# Rezoning Transportation Analysis

Petition Number: 2023-012

**From: Jake Carpenter, PE**  
Jacob.carpenter@charlottenc.gov  
980-221-5675

Revision Log:	Date	Description
	5-24-23	First Review (PDM)
	6-21-23	Second Review (DR)
	8-23-23	Third Review (PDM)
	9-20-23	Fourth Review (JP)
	11-27-2023	Fifth Review (TP)

REZONING
SITE PLAN

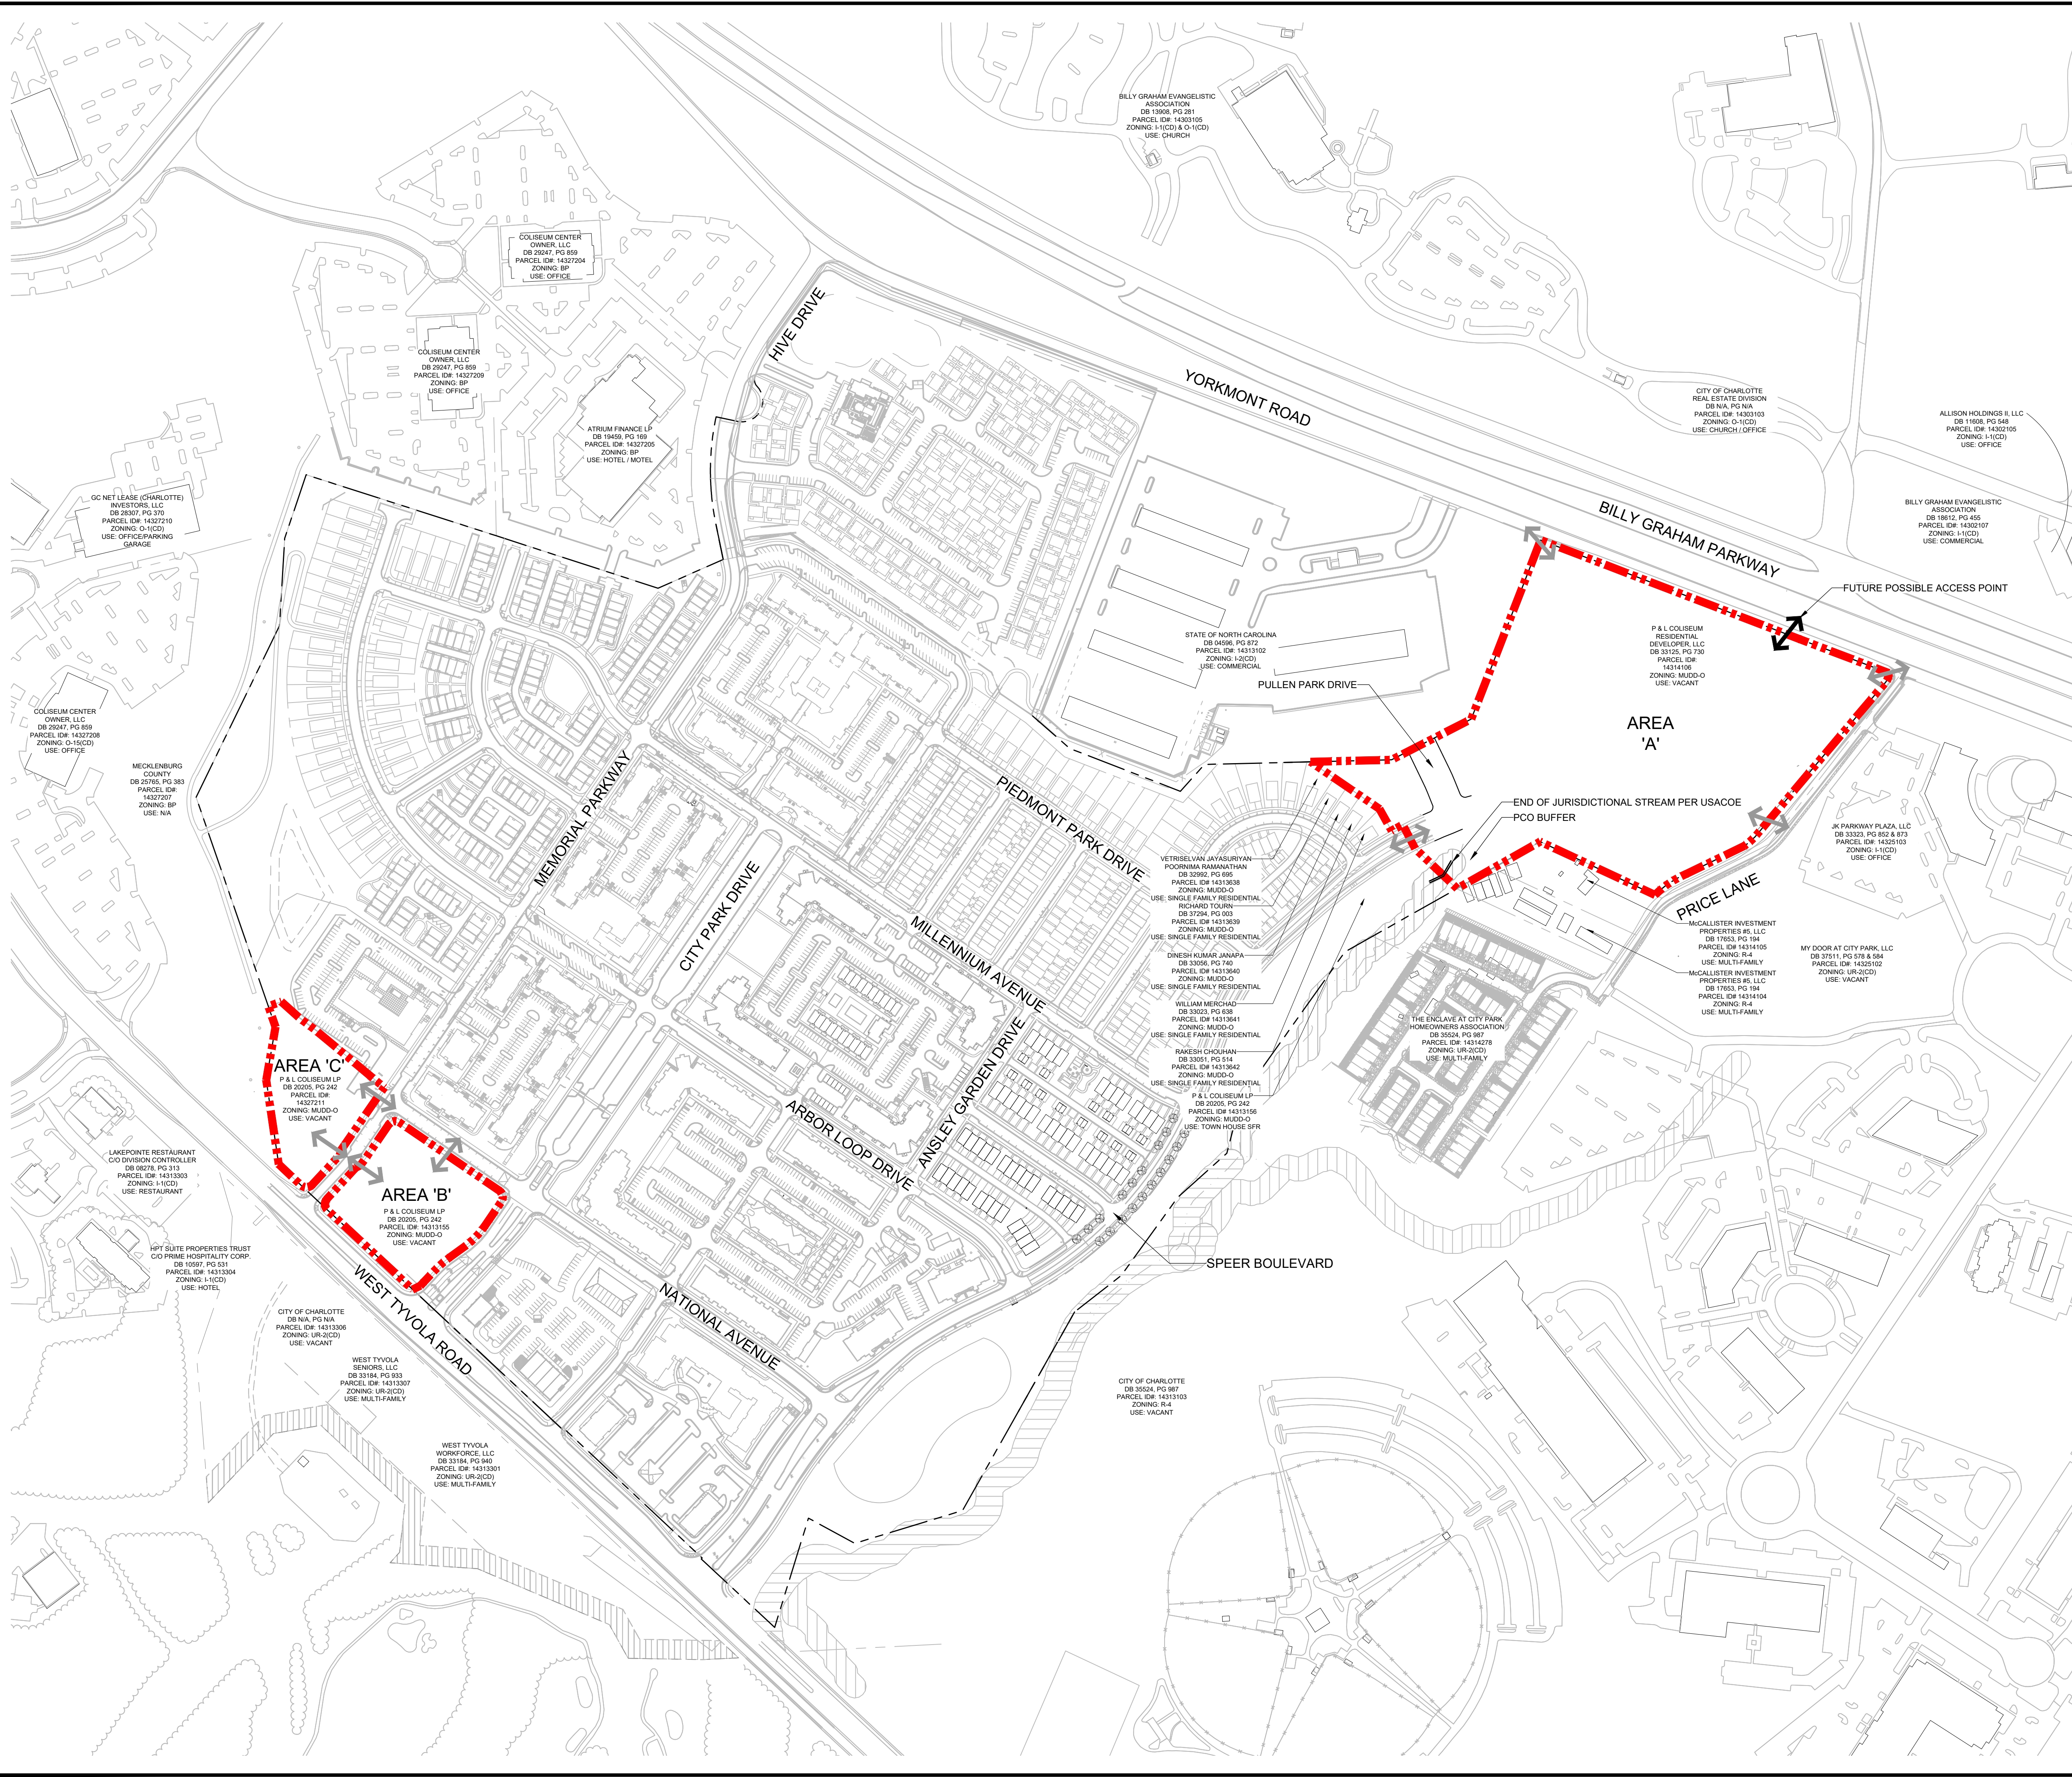
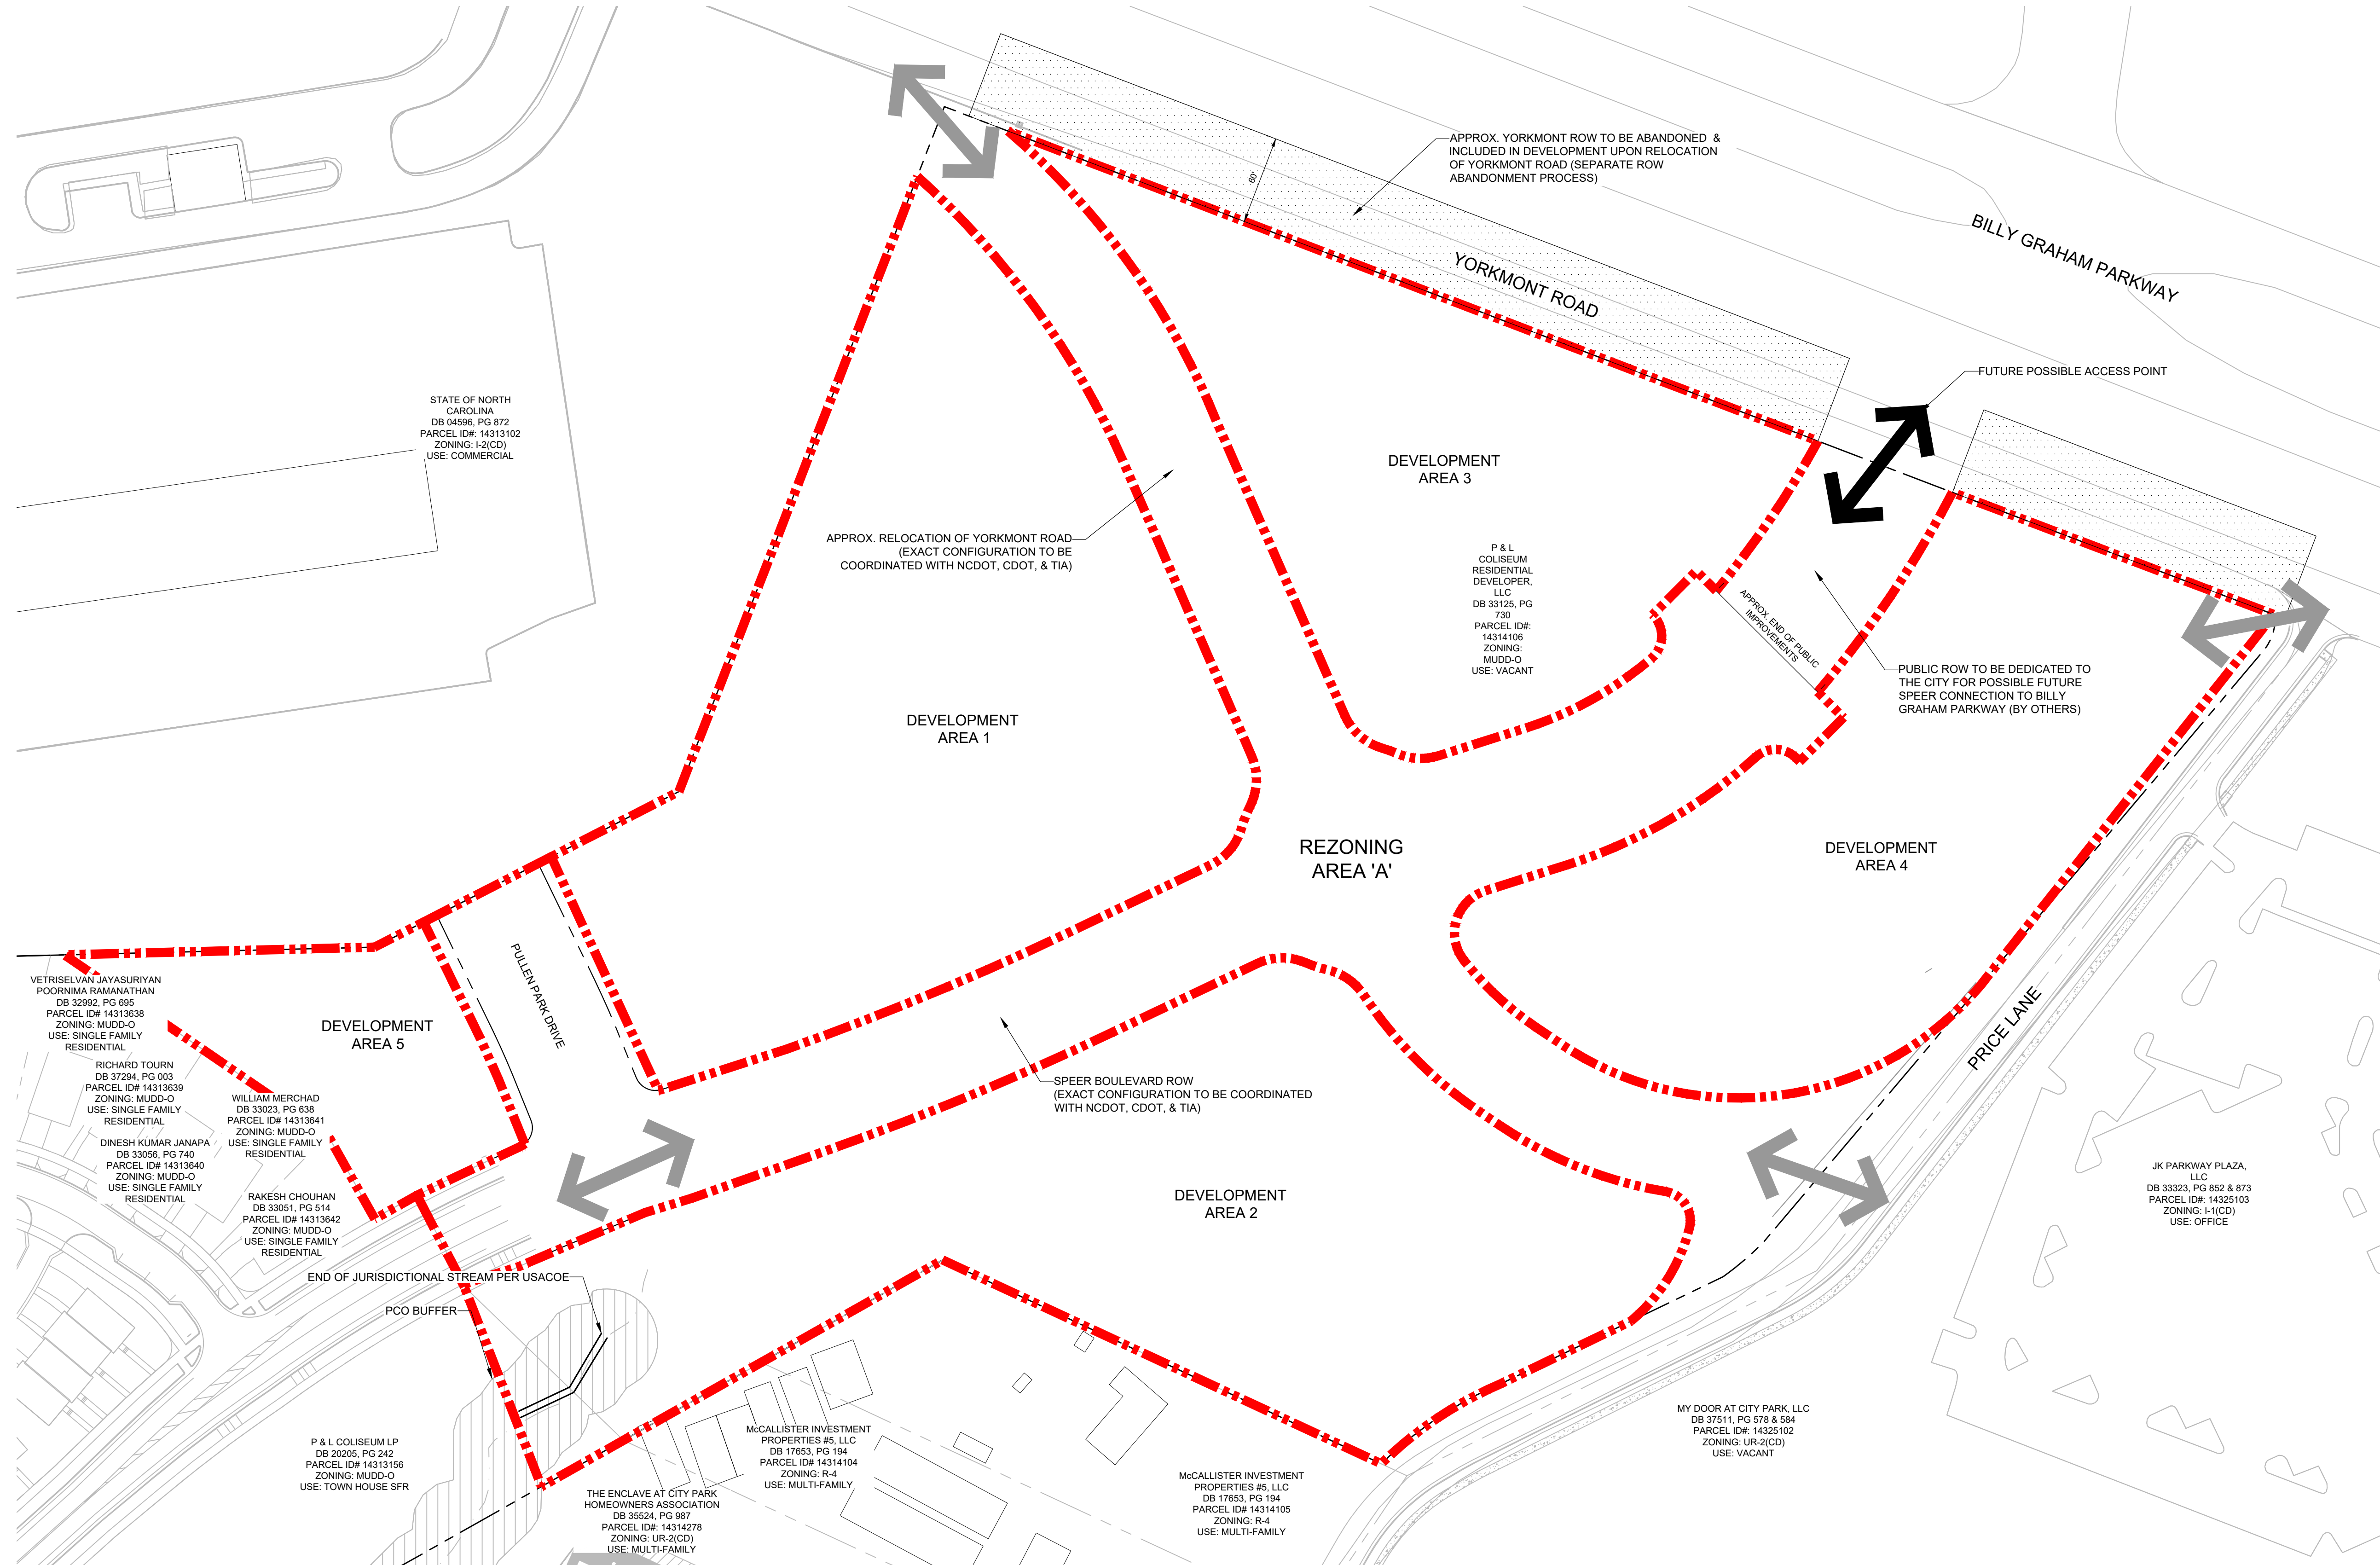
~~Label and dimension the curb and gutter from the centerline for each road on the site plan.~~

**Outstanding Comment from 6.21.23:** ~~Label and dimension the curb and gutter from the centerline for each road on the site plan.~~

**Clarifying comment 6.21.2023:** Add conditional note to dedicate a minimum 35 feet of ROW from the roadway centerline of Yorkmont Road and Speer Boulevard. Additionally label and dimension.

**Clarifying comment 6.21.2023:** Add conditional note to provide 8 foot planting strip and 8 foot sidewalk along Yorkmont Road and Speer Boulevard. Additionally, revise to show 8 foot sidewalk.

**Clarifying comment 6.21.2023:** Add conditional note about ROW dedication to the City for possible future Speer connection to Billy Graham Parkway. Speer Road Stub needs to be extended to property line if it will not tie into Billy Graham Parkway.
